Subject: FW: Planning Consultation on LU/295/19/DOC

In respect of application for Discharge of Condition 10 – Construction Management Plan

I have reviewed the Construction, Environment & Management Plan, May 2019 in this case. Please would you contact the applicant to ensure the following matters are addressed:-

Construction Management Plan Layout

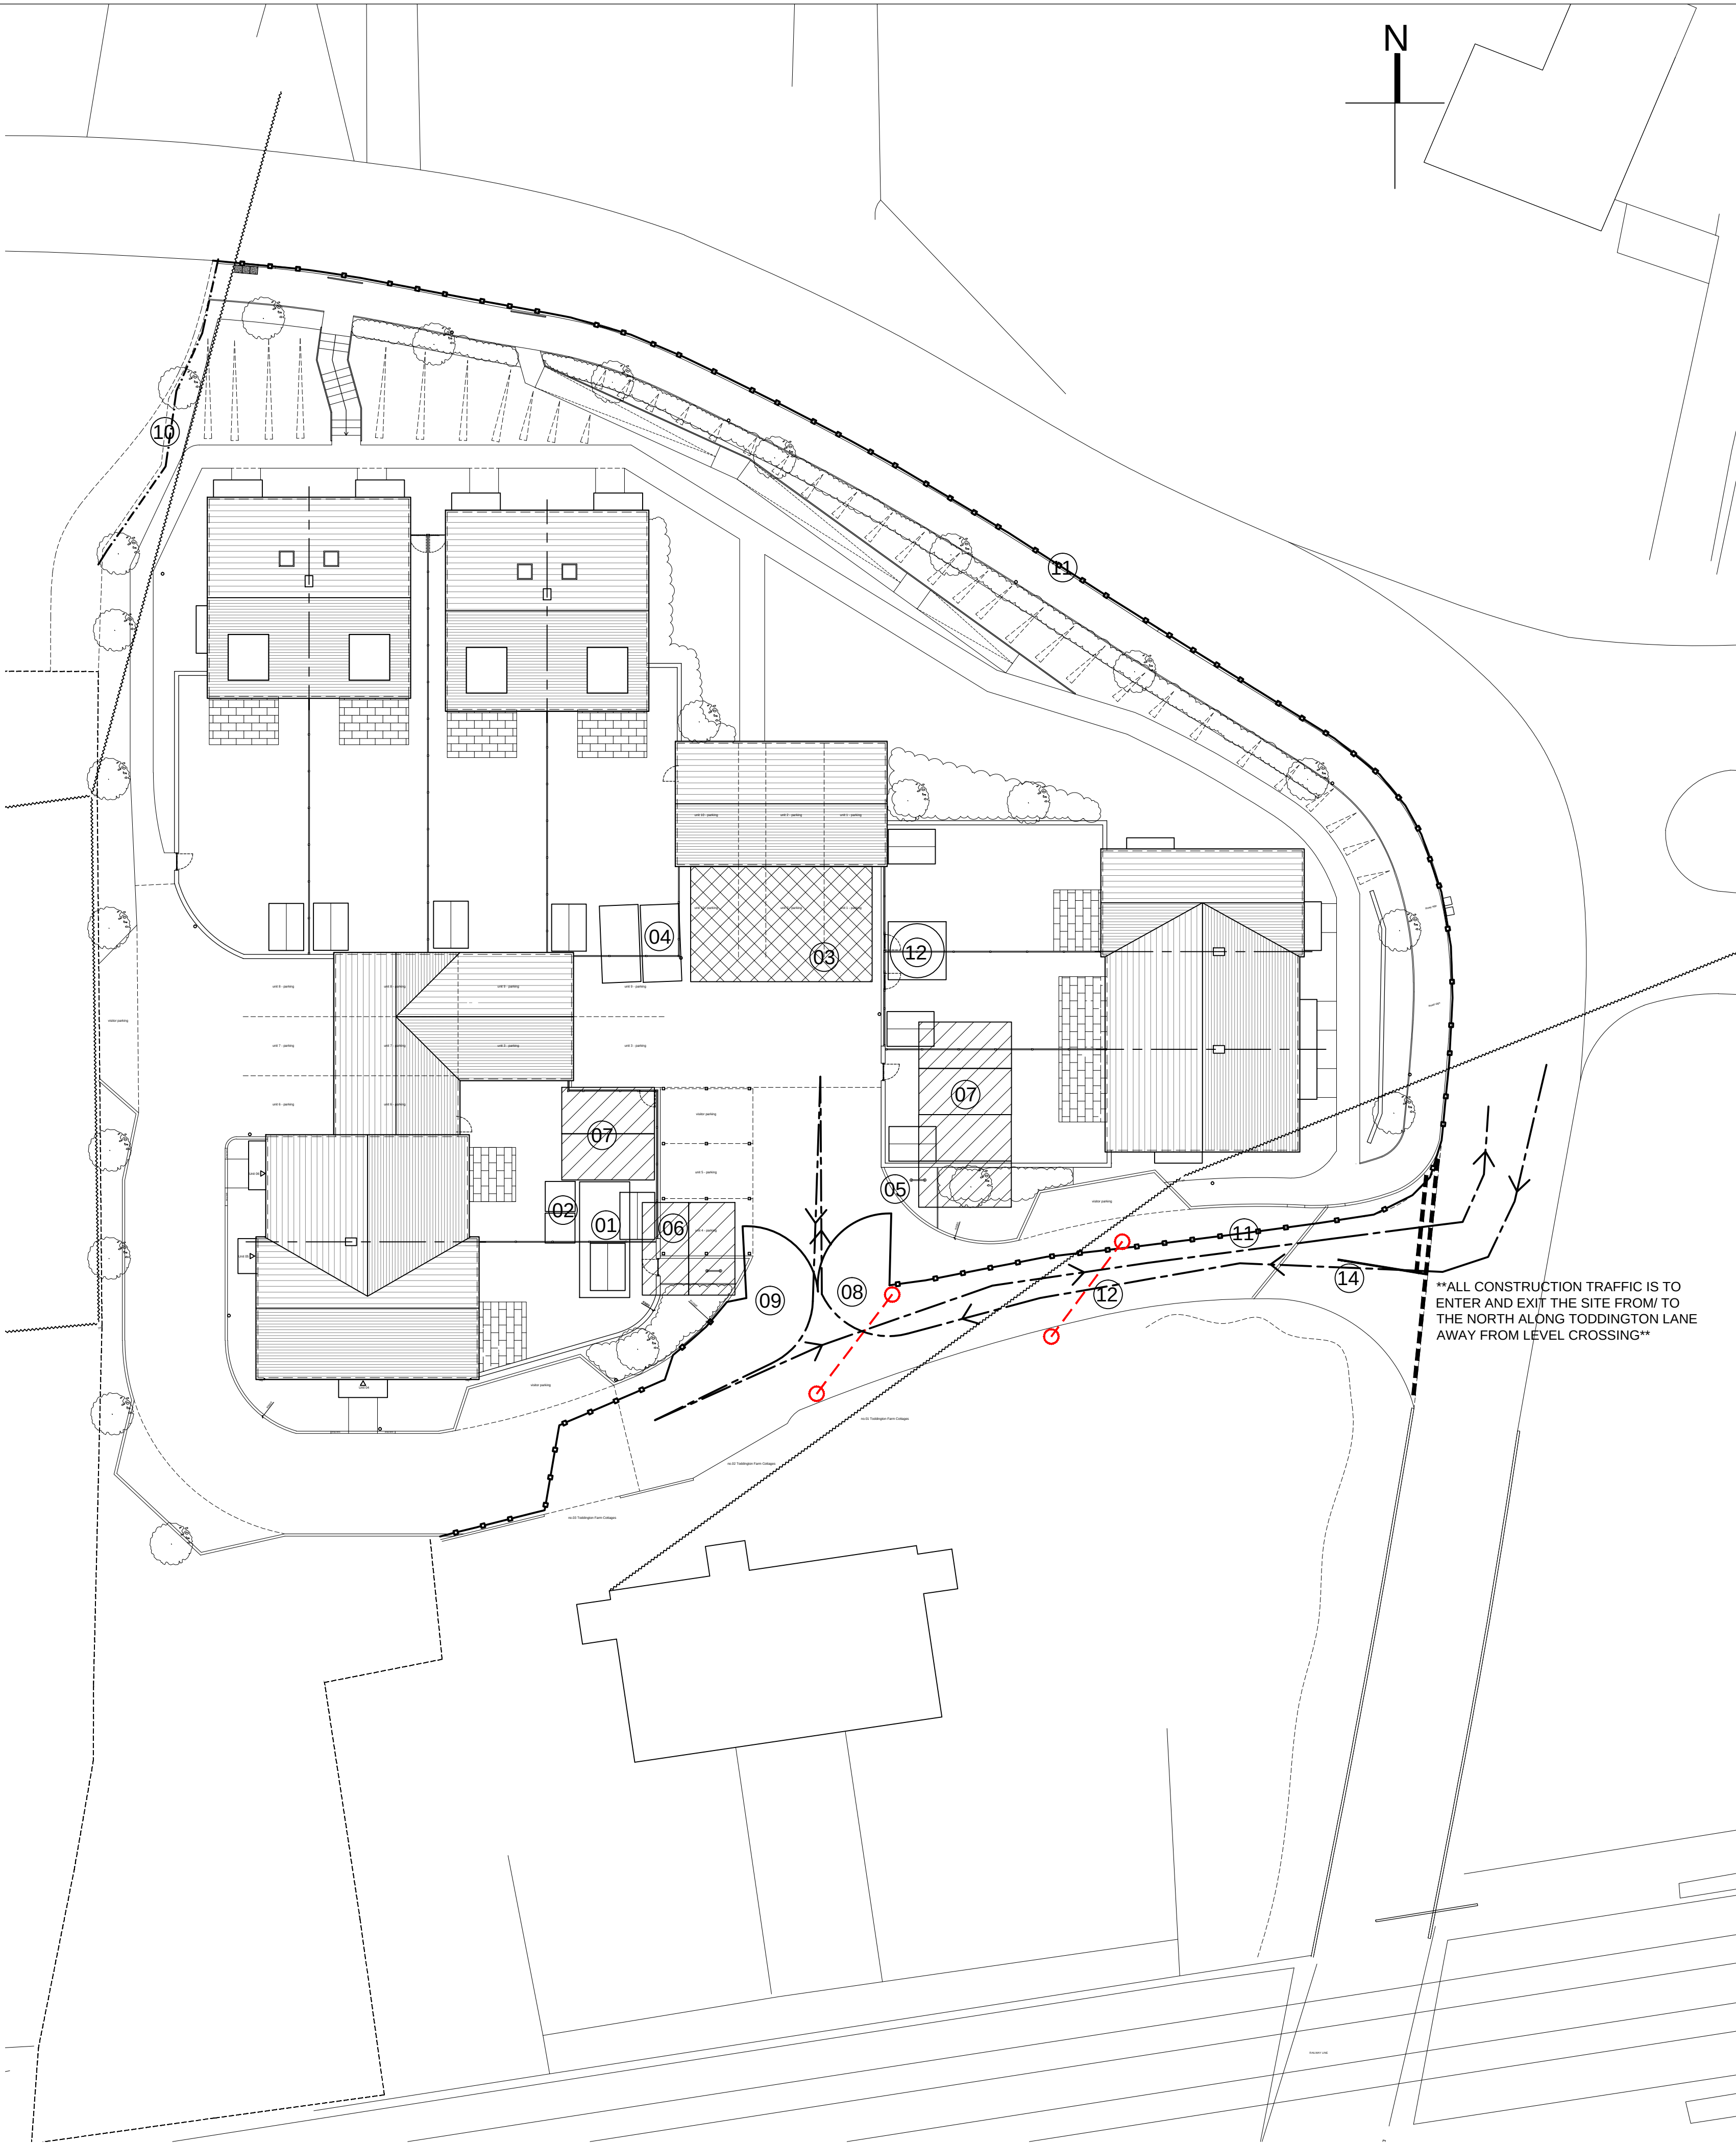
*Page 8, end paragraph 2.2. 'Materials stored in dedicated areas.' Please can the applicant provide a plan showing the intended location of such storage facilities.

DRAWING TITLE
Construction Management Plan Layout

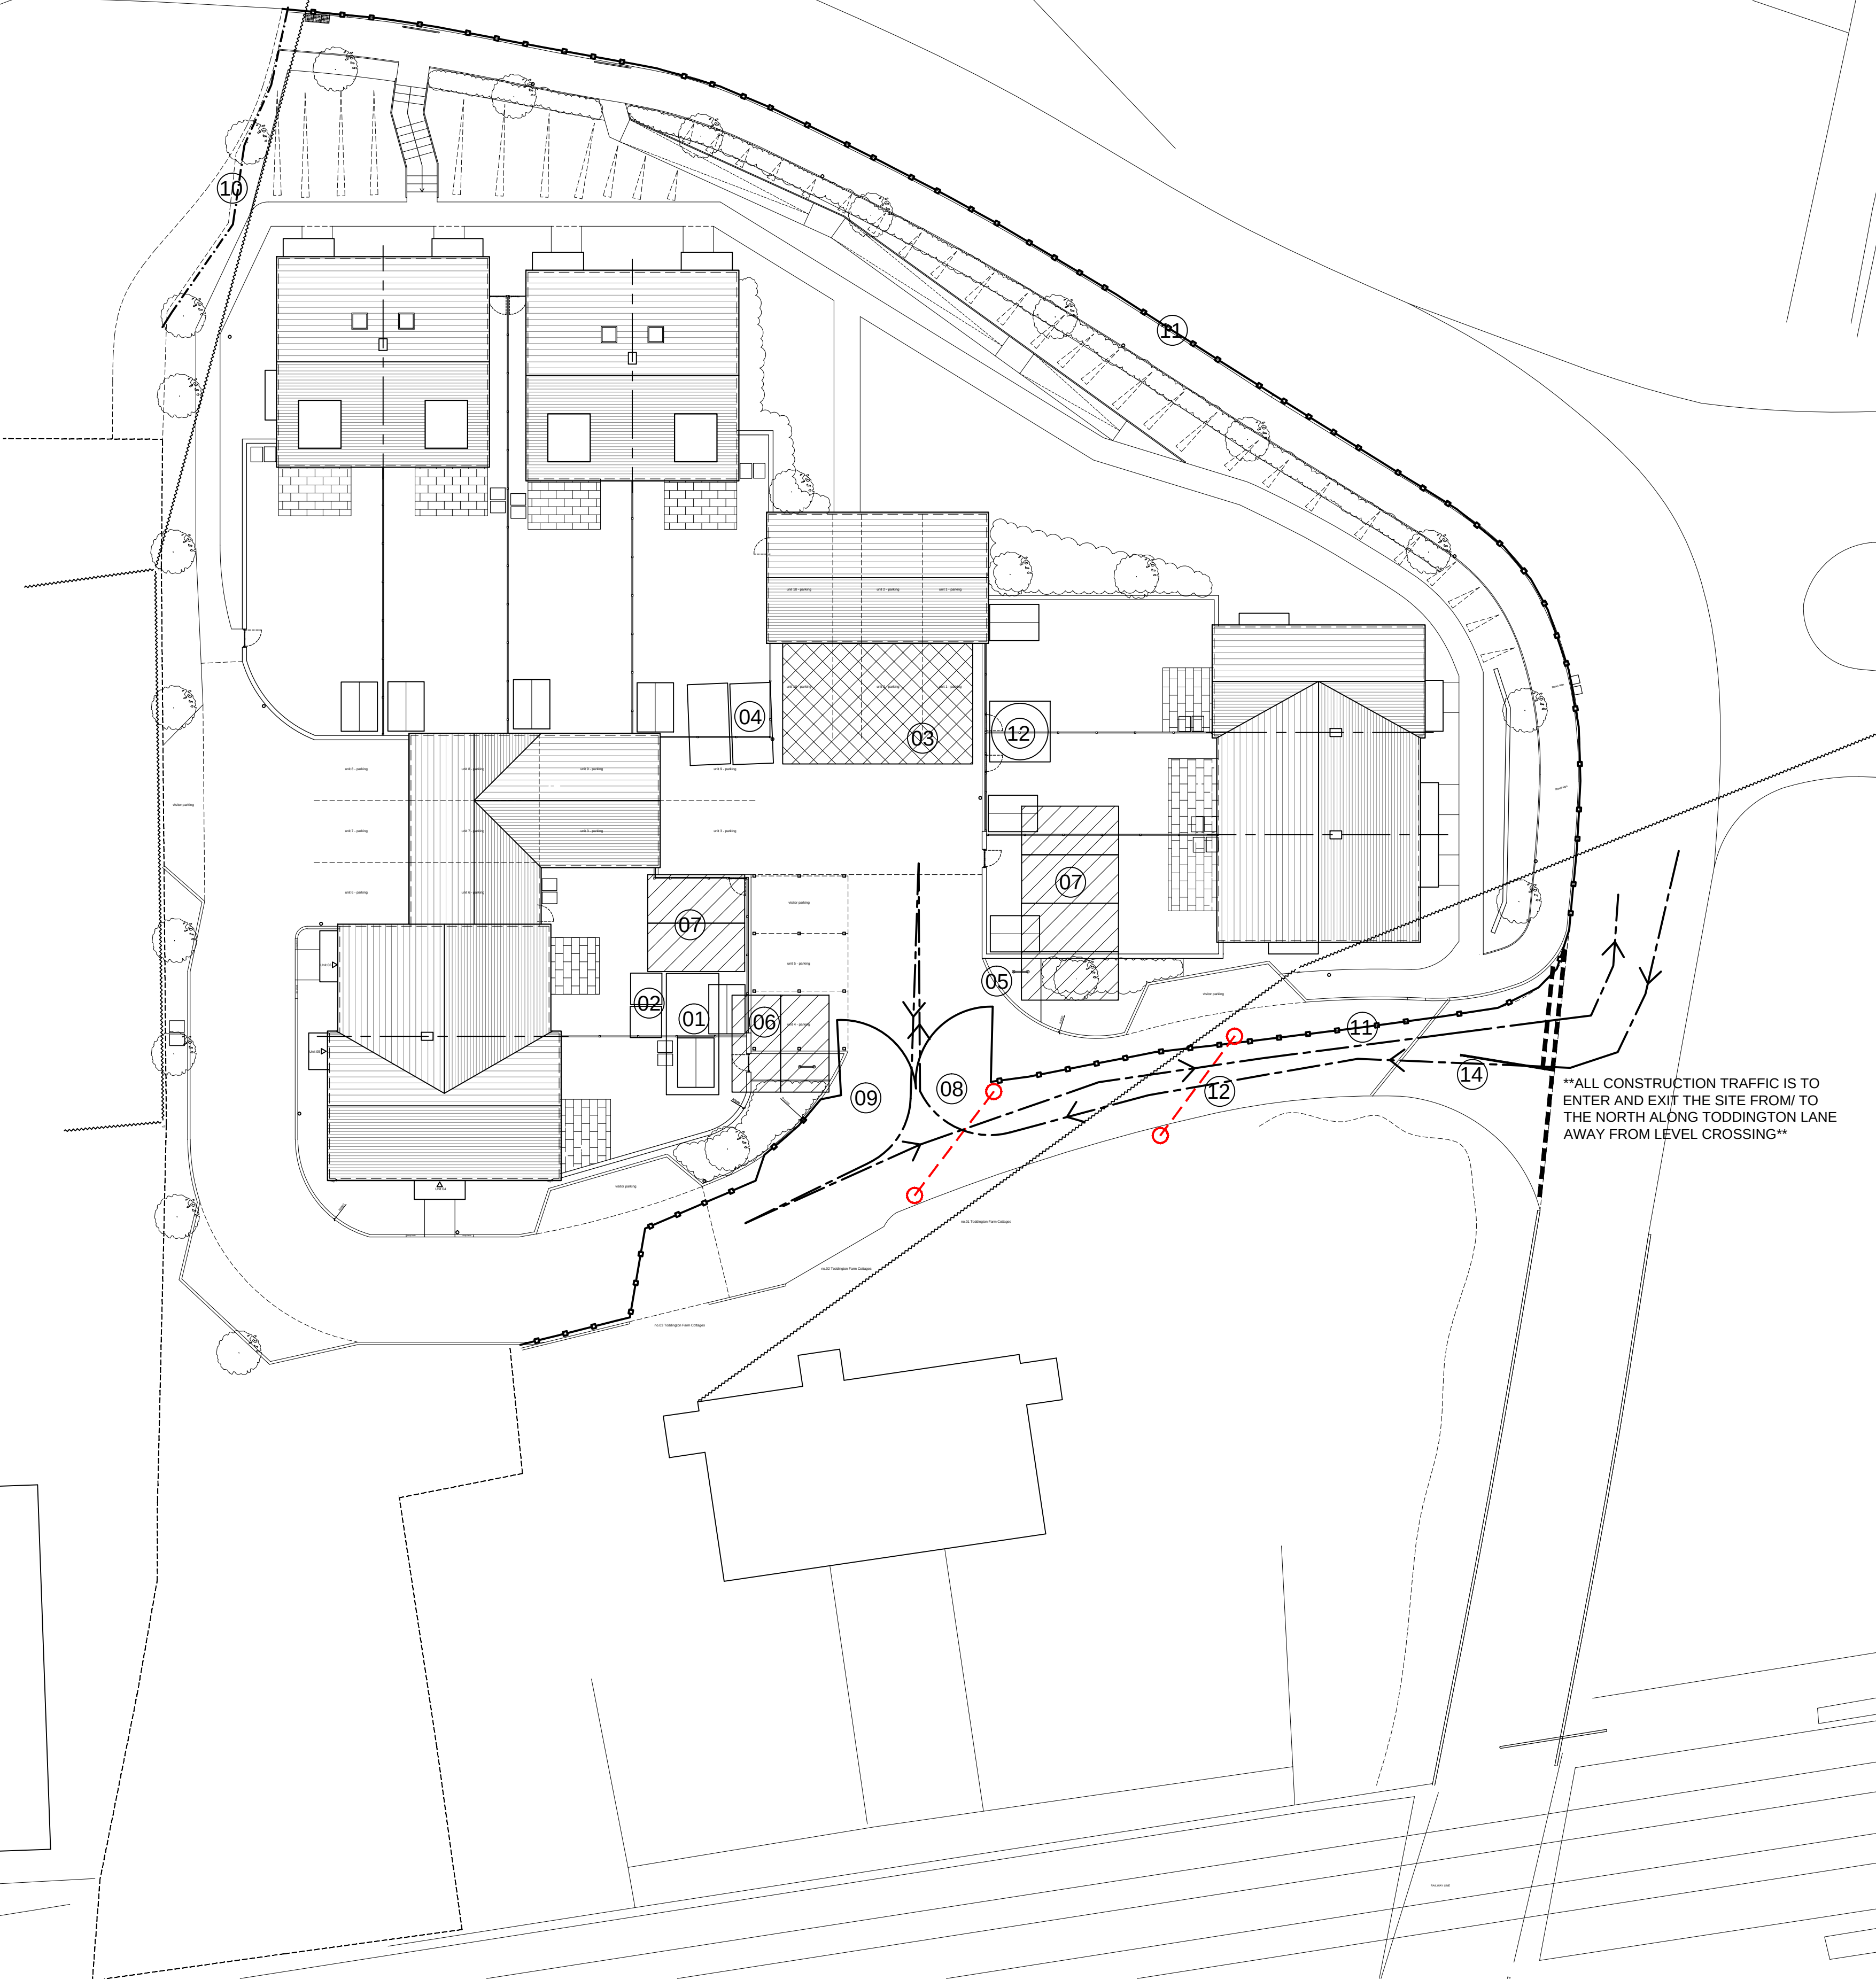
*Page 8, final paragraph. Please can the applicant provide the intended nearby location for holding delivery vehicles prior to arrival on site.
